To Kathryn Hughes Ref: 3/2023/0012 &
3/2023/0013

Subject Conservation Comments

Proposal: **Listed Building Consent Application and planning permission for proposed conversion of outbuilding and existing holiday let to create annexe for multi-generational family living to sustain the use of the listed farmhouse, works proposed are within the curtilage of listed building.**

Site Address: **Little Blacksticks, Blacksticks Lane, Chipping Lancashire PR3 2WL**

Rev.	Date	Revision Notes
Project Title		
LITTLE BLACKSTICK'S CHIPPING		
Drawing Title		
DETAIL DRAWINGS		
Drawing No.	Revision	
2213A.03.03		
Date	MARCH 2023	Scale 1:100 @ A2
Drawn by:	JMC	Checked by: SAL
northwestdesigncollective		
• e: hello@nwdcstudio.com • t: +44(0)1772429840

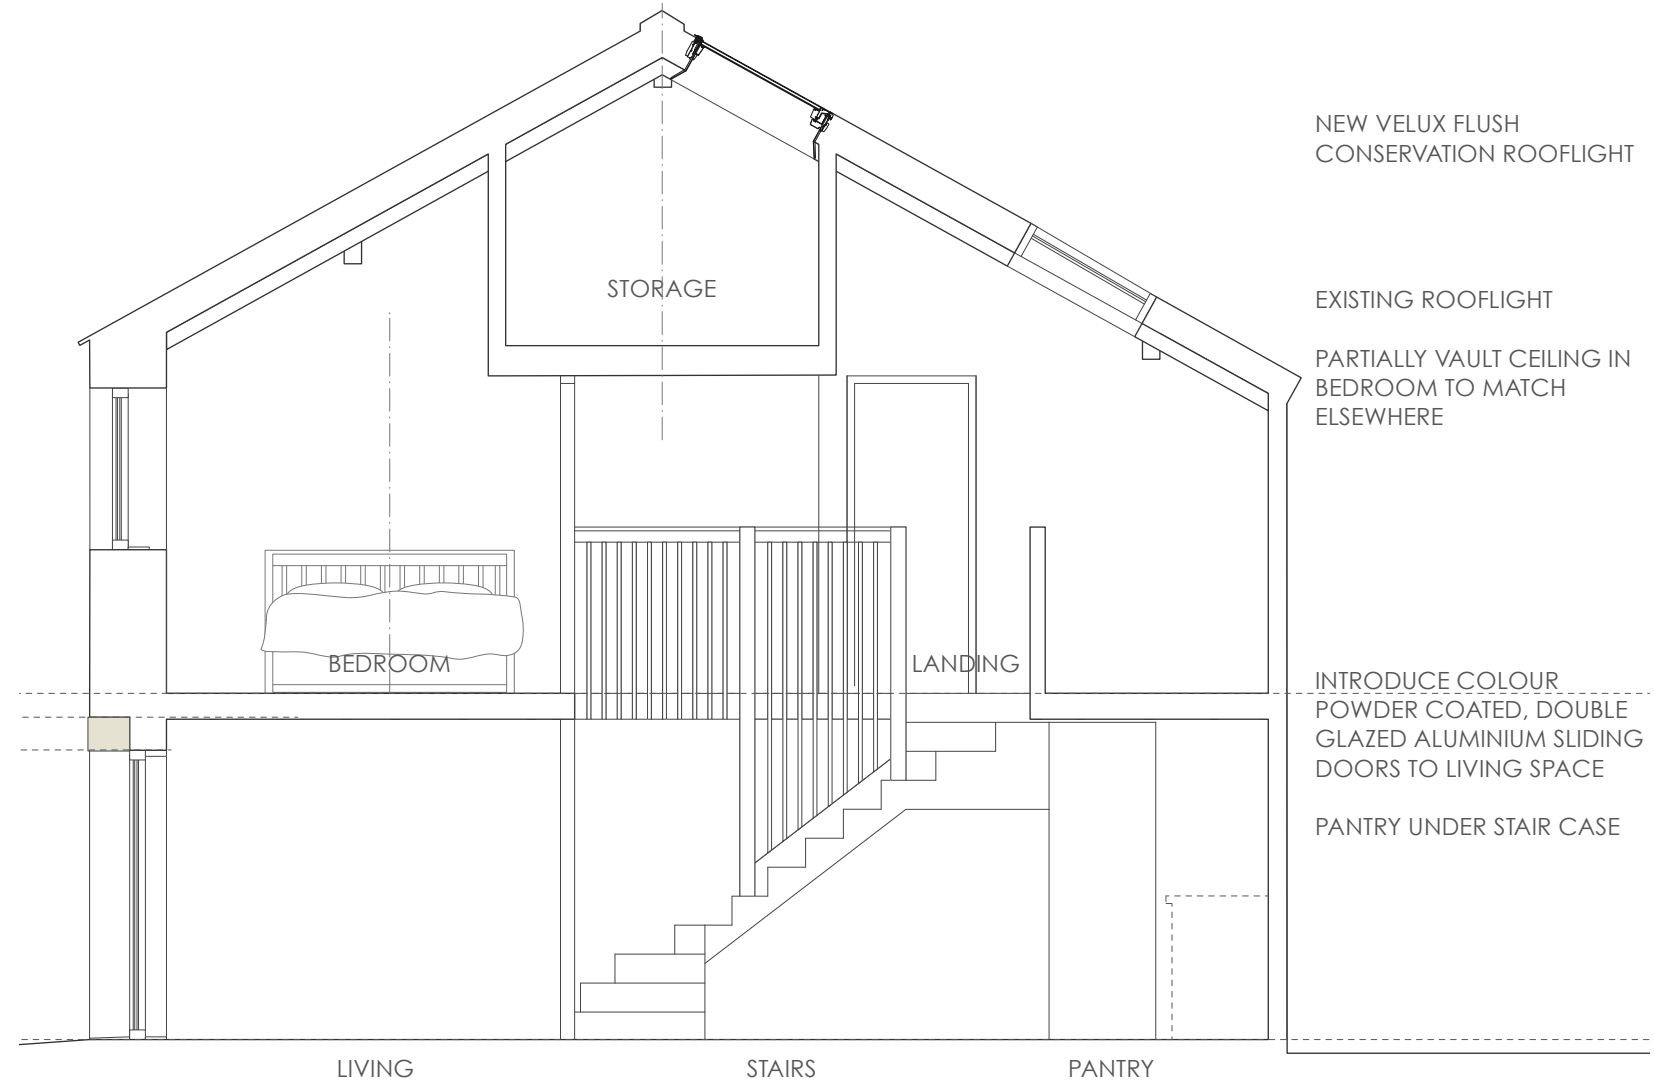
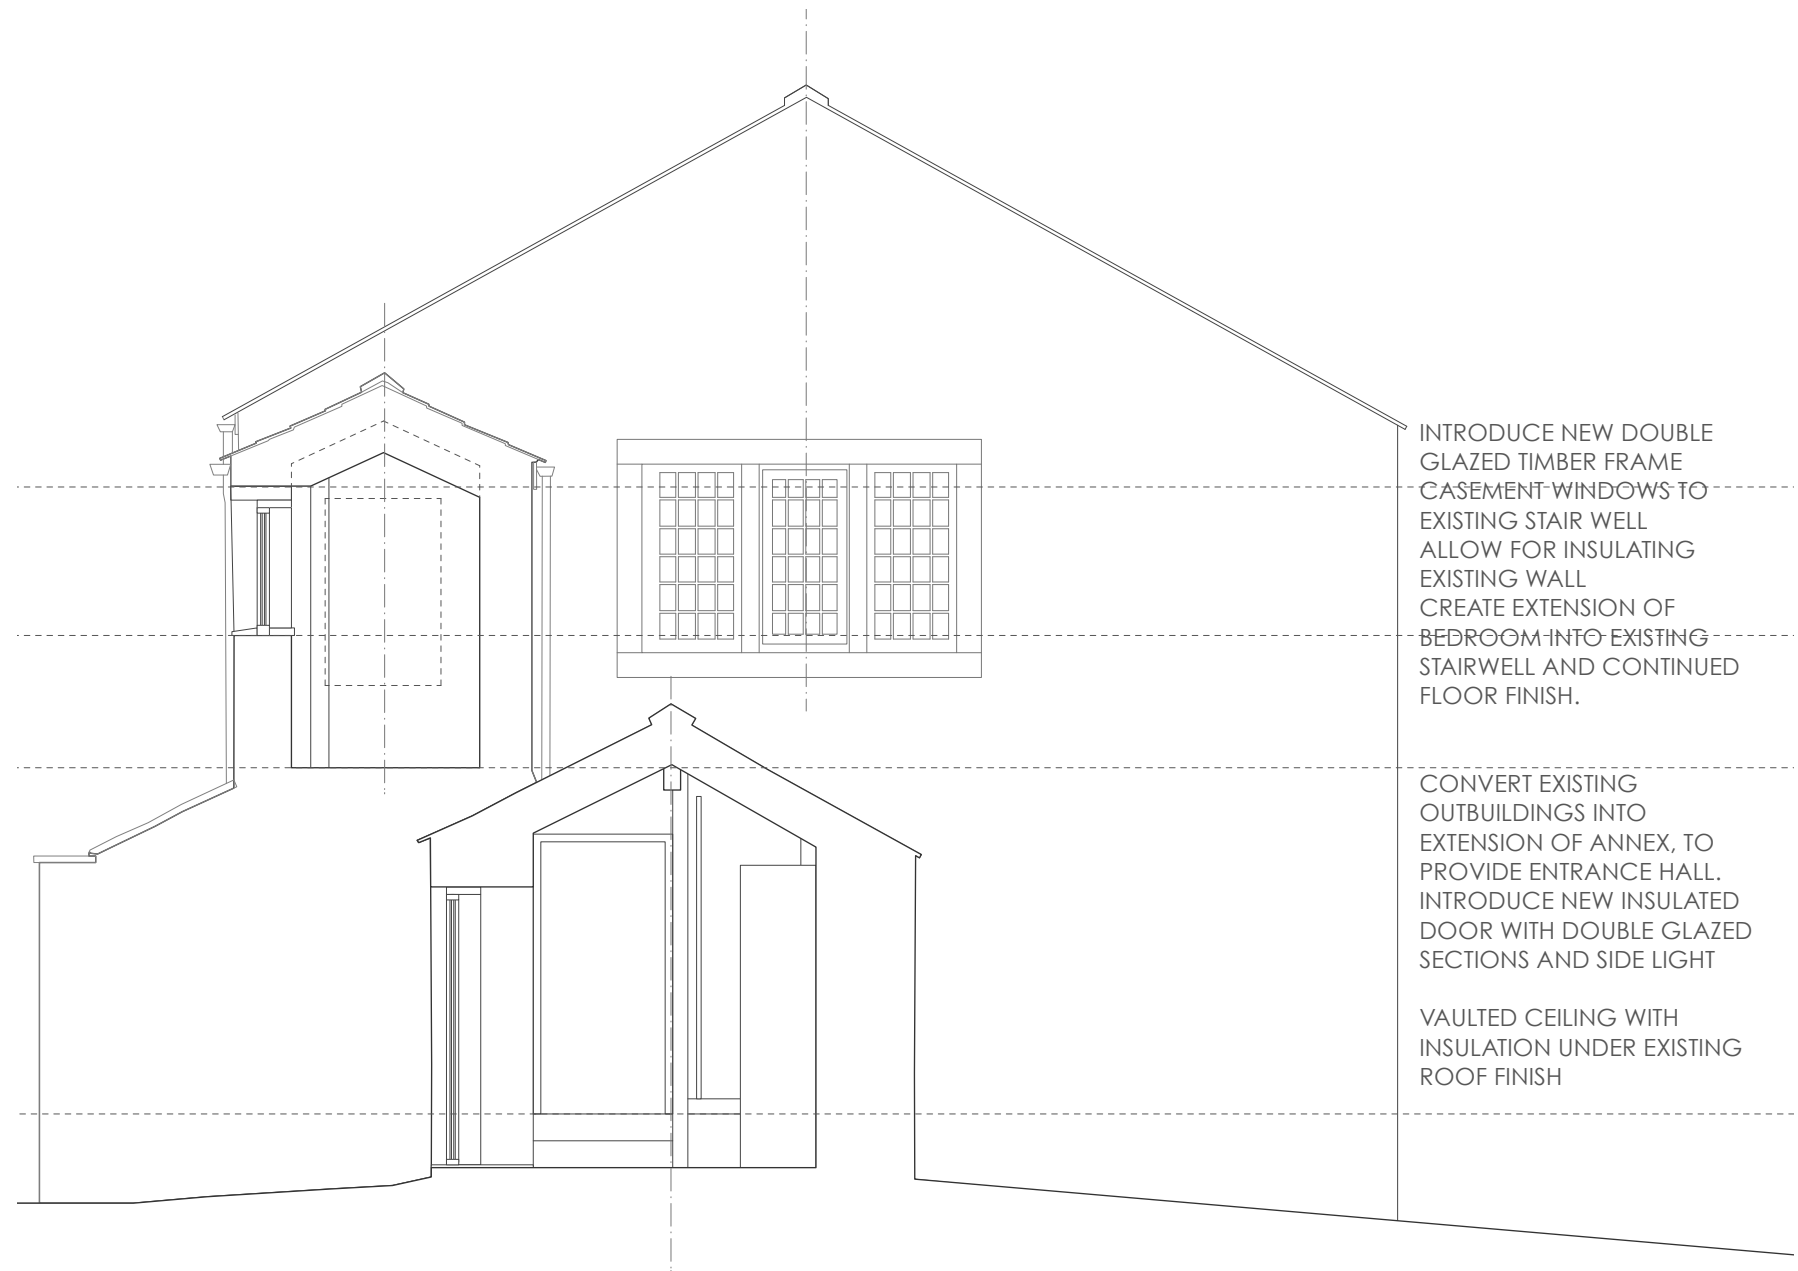
However, design details of the proposed windows have not been provided and I would recommend that further information relating to the design of windows is provided, or secured by a suitably worded Condition. Likewise, I do not object to the installation of the additional rooflights on the southern roof slope. Whilst there are already two rooflights in situ on this elevation, they are located on the roof slope facing away from the listed building and cannot be viewed from within the grounds or any important public vantage point.

As such, subject to clarification of the proposed window design, it is my view that any harm caused as a result of the proposed works will be negligible and this is more than offset by the proposed active use of the outbuildings and the benefits of retaining the group of buildings.

Subject to further details as relating to the proposed window design, I consider the current proposal would meet the statutory test 'to preserve', causing no discernible harm to the significance of the listed curtilage buildings, or to the contribution made by the setting to the principle listed building. Therefore, I do not feel the LPA would be required to undertake a balancing exercise is required as per NPPF P.202.

| Rev. | Date | Revision Notes |
|--|---------------------|----------------|
| Drawing Title PROPOSED PLANS AND ELEVATIONS | | |

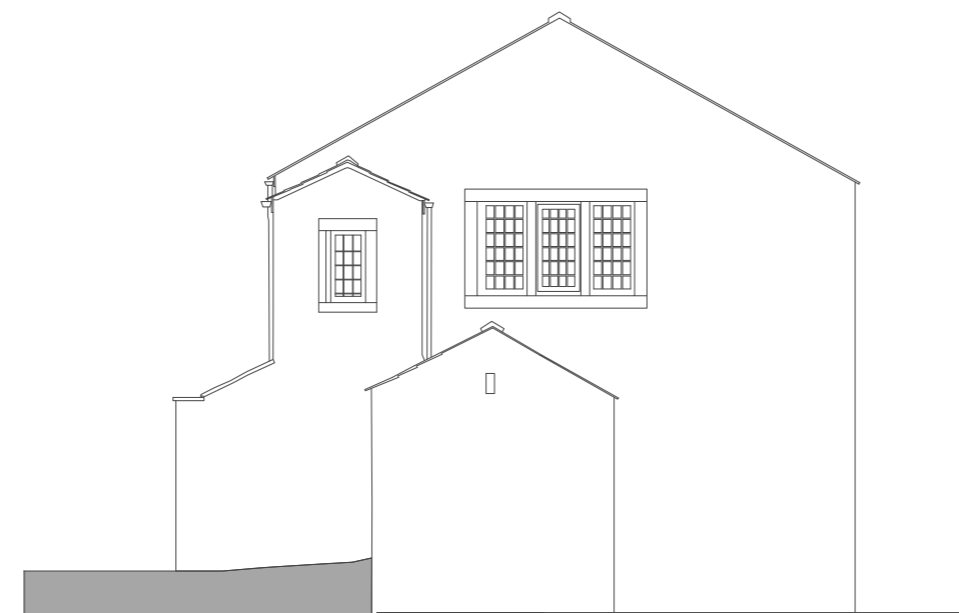
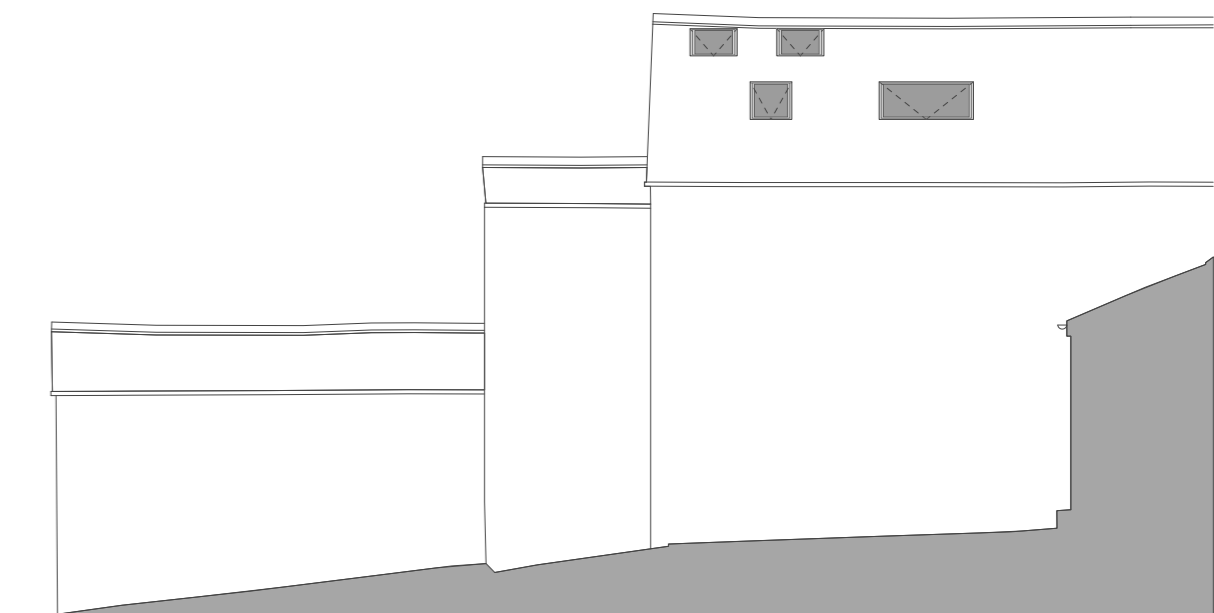
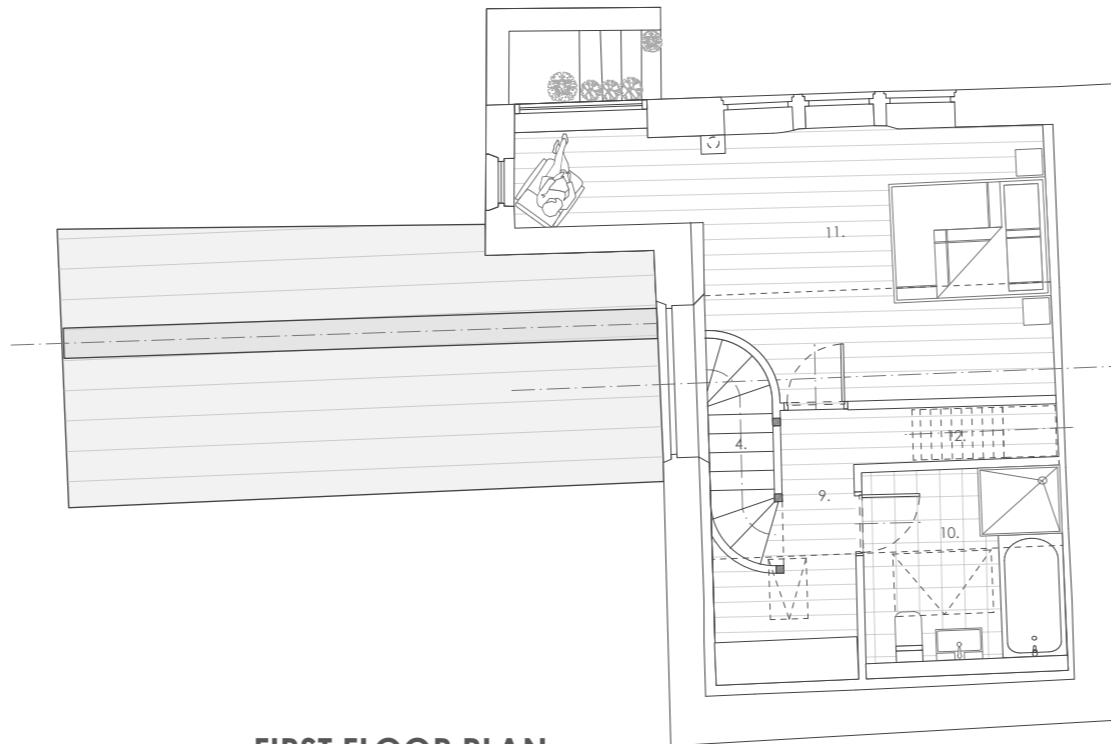
The proposed scheme seeks to internally connect the collection of outbuildings to southeast corner of the site. The proposed works include the infilling of the existing large opening on the GF front elevation, which will be partially infilled with a window and stone wall to match existing. This will allow for the re-siting of the living and kitchen space to the ground floor of the former barn, and noted as to 'take advantage of the existing large structural opening to introduce large glazing that can allow light to percolate deep into the floor plan'.

I do not object to the relocation of the kitchen and living space to the existing open storage area nor to the infilling of the large opening on the ground-floor. Whilst a large window opening is somewhat out of character with the building itself I accept that the large opening is already in situ and the proposed design is simply utilising this existing opening.

Similarly, the proposed new window to encapsulate the existing external staircase to provide an additional indoor space is acceptable. Whilst the existing entrance will no longer be used, the opening remains (internally) as well as a large proportion of the external staircase, evidencing its former use.

On considering the alterations to the washhouse and former stables, internally other than their plan form and materials, there is little of intrinsic value remaining. Although, the proposed new opening into the former barn will result in the loss of some historic fabric, I think the alteration is still minor in the context of the group of buildings and their overall significance. Formerly, the washhouse and stables were linked via an opening that has since been blocked up and as such providing a new opening here (although not directly reinstating a former opening) will not result in any additional harm. Externally, the existing doorways are to be retained including the stable door. By inserting a new fixed glazed window behind the
